# Technical Memorandum

**Re:** Response to Comments, Permit #CU-23-00006  
Honest Cut Meats LLC Conditional Use Permit

### RE: CU-23-00006 Honest Cut Meats LLC- Transmittal of Comments

DATE: 10/30/2023
JOB: 2619.0001
BY: DDS
SCALE: 1" = 80'
FIGURE NO. 3 of 3

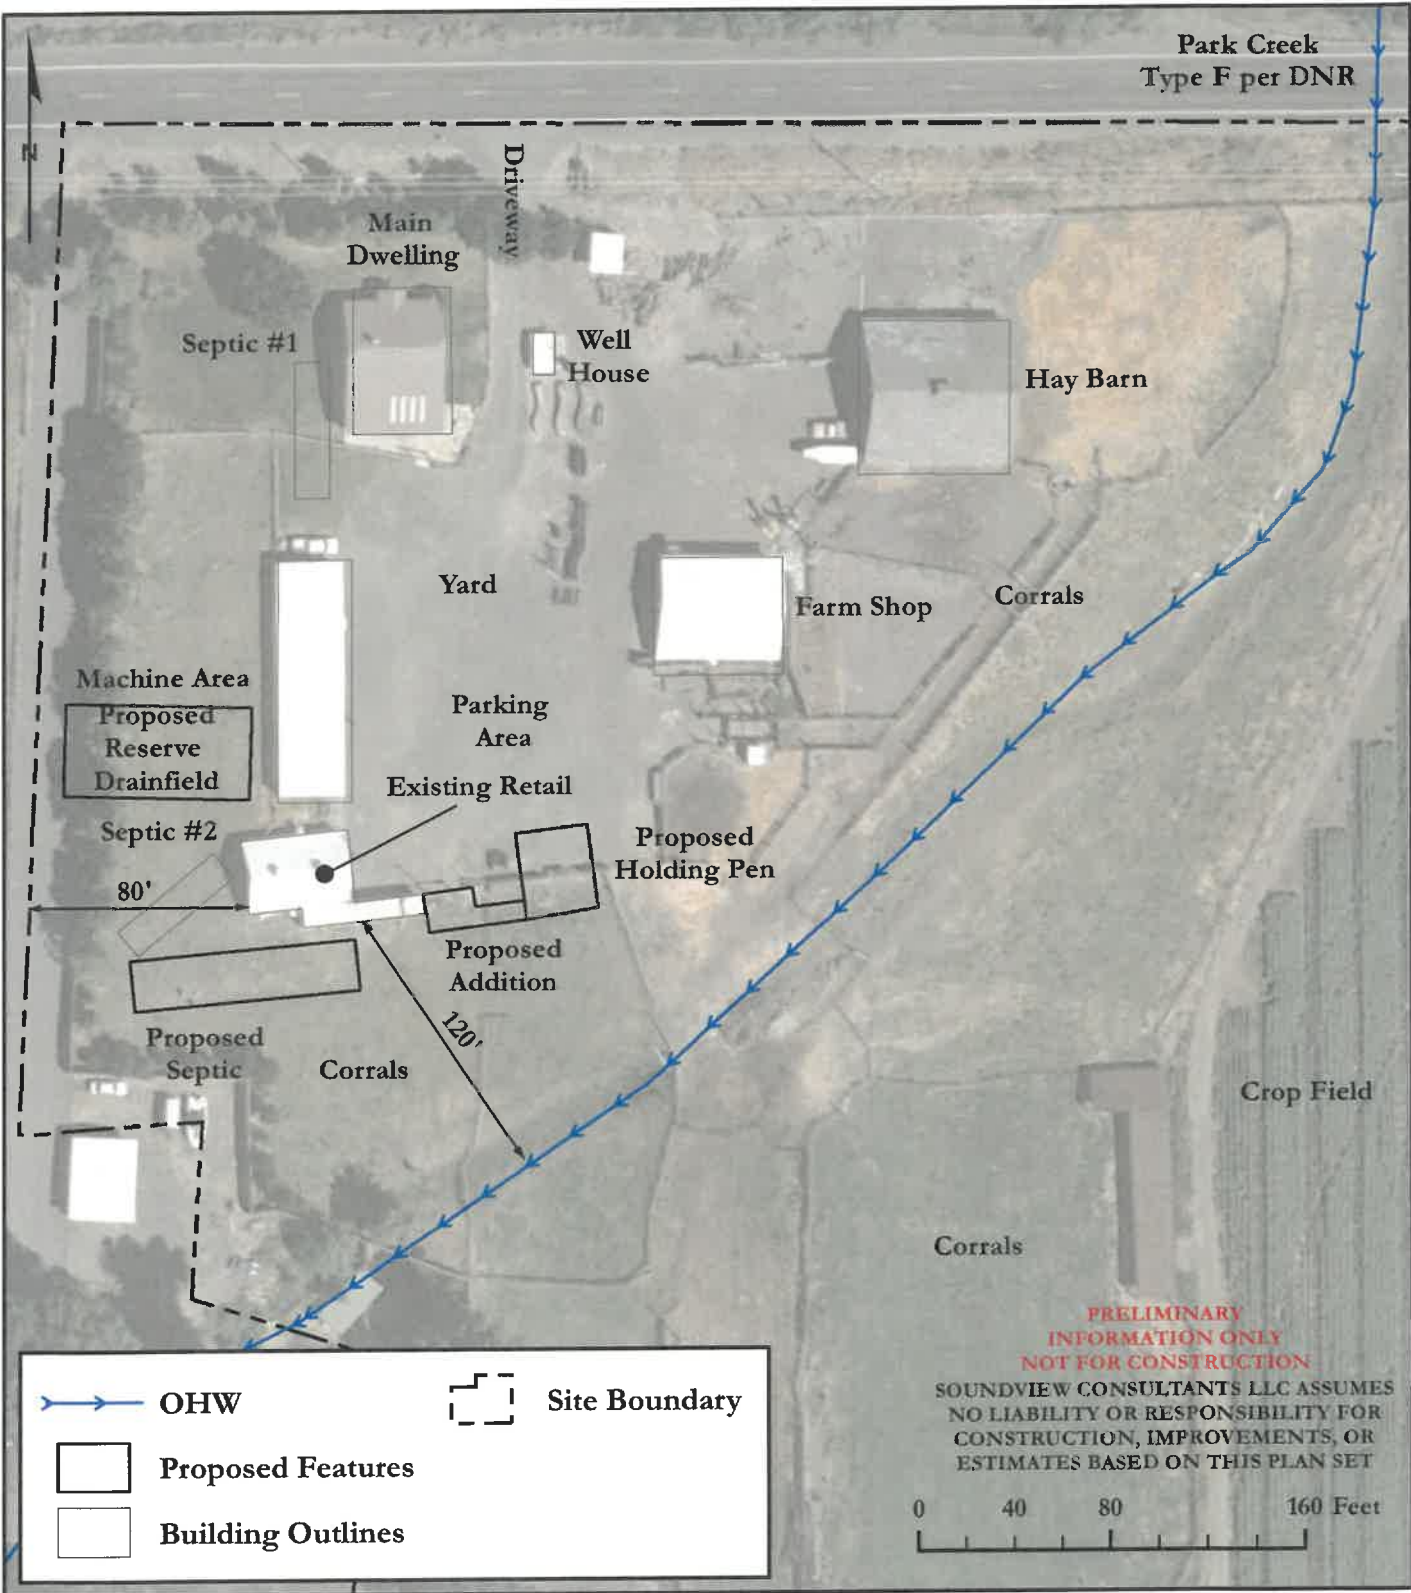
The use of prefabricated structures is likely to minimize the overall footprint and disturbance associated with the project, however there will be at least 480 square feet of new impervious surfaces near Parke Creek and a proposed holding pen that will likely send runoff toward Parke Creek. At least portions, if not all, of the development is within 100 feet from Parke Creek. The standard buffer width in the County's Critical Areas Ordinance would call for a 100-foot buffer plus a 15-foot setback. WDFW's guidance for riparian ecosystems in this location also recommends a 100-foot minimum setback to protect water quality. Ecology's [Voluntary Clean Water Guidance for Agriculture](#) recommends animal confinement areas (holding pens) be placed at least 150 feet away from streams in Eastern Washington and livestock exclusion of at least 100 feet to allow for a fully functioning riparian ecosystem.

The proposed prefabricated structures appear to be located near or within the 100-year floodplain as mapped by FEMA. Unmitigated placement of structures within the floodplain may result in

Enhancing the Park Creek riparian corridor or relocating the proposed development further away from Park Creek is beyond the scope of the proposed project, as it would significantly interfere with ongoing agricultural practices on the property. However, to minimize potential impacts from the proposed development on Park Creek, the Applicant will be constructing the holding pen on a new concrete pad and redirecting any waste generated from livestock in the holding pen away from Park Creek, into the proposed septic system or an upland composting facility in compliance with Kittitas County Public Health requirements. Waste generation will also be minimized by limiting the amount of time livestock is kept in the holding pen to 8-10 hours total per week. By constructing the holding pen in an area already used as livestock pens, these efforts will result in fewer impacts to Park Creek compared to current conditions.

Floodplain development requirements will be addressed through the County's floodplain development permit required by Kittitas County Public Works. No compensatory flood mitigation is proposed.
